**KIRKLEES METROPOLITAN COUNCIL
INVESTMENT & REGENERATION SERVICE**

**DELEGATED DECISION FOR DISCHARGE OF CONDITION -
NOTIFICATION OF A CHANGE OF USE UNDER THE ABOVE
PROVISIONS**

Reference no. 2025/CL/93450/W

**Description Prior notification for change of use
of 2 agricultural buildings to 6
dwellings**

BLOCK PLAN
1:500

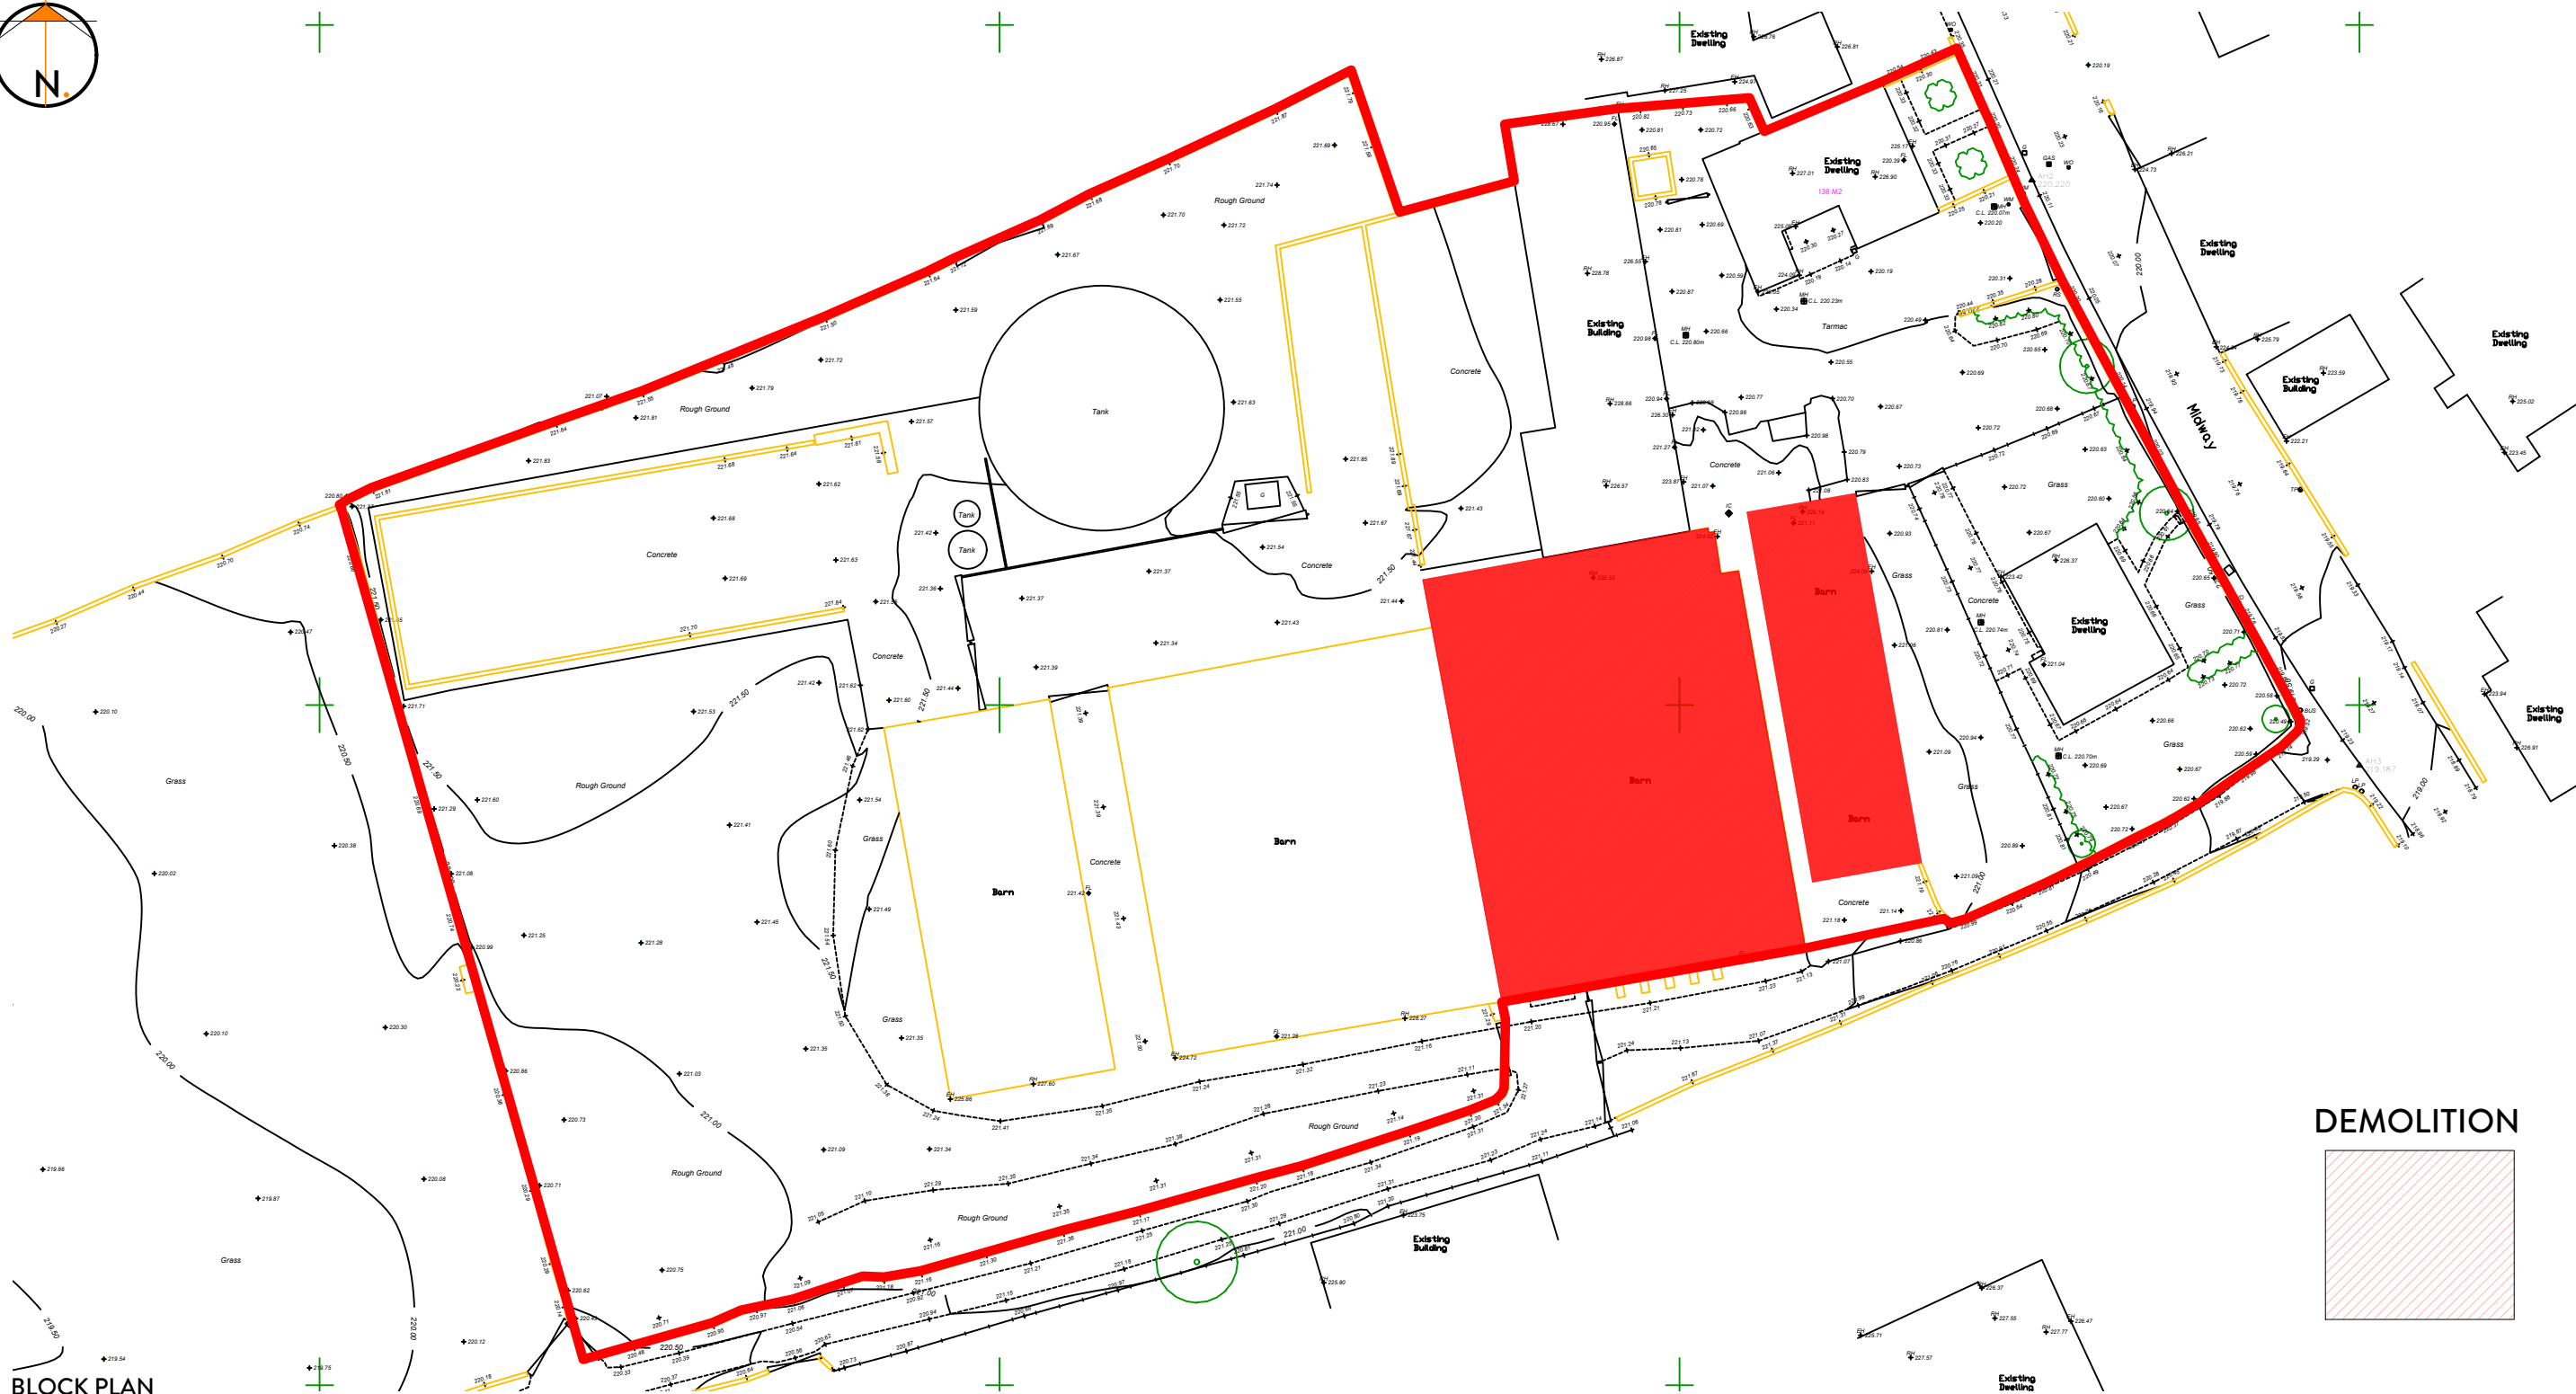
No visibility splays have been submitted for the access. As the proposal would intensify the use of the access, Officers would like to see visibility splays of 2.4m x 43m clearly displayed on a drawing. These should be to the nearside kerb and cross nothing greater than 1m in height. If these full visibility splays cannot be achieved then officers would be happy to see a reduction in the Y-length of the splay based on observed 85th percentile speed data obtained from an ATC on Midway and constructed to Manual for Streets calculations. This should be conditioned for highway safety reasons.

The proposals are for 6 two-bedroom dwellings and to follow local guidance they would require 2 off-street parking spaces per dwelling with one visitor parking space per 4 dwellings. The proposed block plan shows that 12 resident spaces and two visitor spaces can be provided with suitable turning and manoeuvring space and this is acceptable. The parking areas should be either finished with a permeable surface or include suitable drainage if an impermeable surface is to be provided, no water run-off should be allowed to enter the highway.

The extent of the works required to accommodate the development would see the creation of an access across part of the site where there is currently no access in place. In addition, there would be the creation of a large area of vehicular parking.

The proposed works to create the access and parking area would fall beyond the scope of that which is permitted by class Q which permits the change of use of a building, associated extension and building operations reasonably necessary to convert the building.

In the absence of a lawfully constructed access and parking arrangement, whilst those shown on the submitted plans are considered suitable by the Highways Team, they would not be able to be lawfully constructed by virtue of Class Q of Part 3 of the Town and Country Planning (General Permitted Development) Order 2015 (as amended). In addition, there is no planning permission in place which would permit the construction of this access and parking area.

Therefore, whilst it is demonstrable that a suitable access arrangement could likely be put in place, there is no lawful basis for securing this access / parking arrangement or for its construction. Therefore, the transport and highway impacts of the development cannot be concluded to be acceptable given there is no existing access / parking area which can be lawfully utilised.

However, review of the planning permission referred to (2025/90570) clear demonstrates that the consent was on the basis of the following description 'Planning permission for demolition of agricultural buildings'. The plans submitted as part of 2025/90570 do not set out the access shown in the plans submitted as part of this application seeking prior approval. The description of development for 2025/90570 only permits demolition.

It is therefore concluded that there is no permission in place to allow for the lawful construction of the access shown on the submitted plan. Analysis of aerial imagery from 2021 shows that the access has not been constructed at that time and therefore it is not possible for the access to have been constructed and become lawful by virtue of the passage of time.

On the basis the buildings do not have suitable existing access to a public highway the development is considered to be contrary to Q.1(p) of Class Q of the Town and Country Planning (General Permitted Development) Order 2015 (as amended) and would not have an acceptable transport and highways impact.
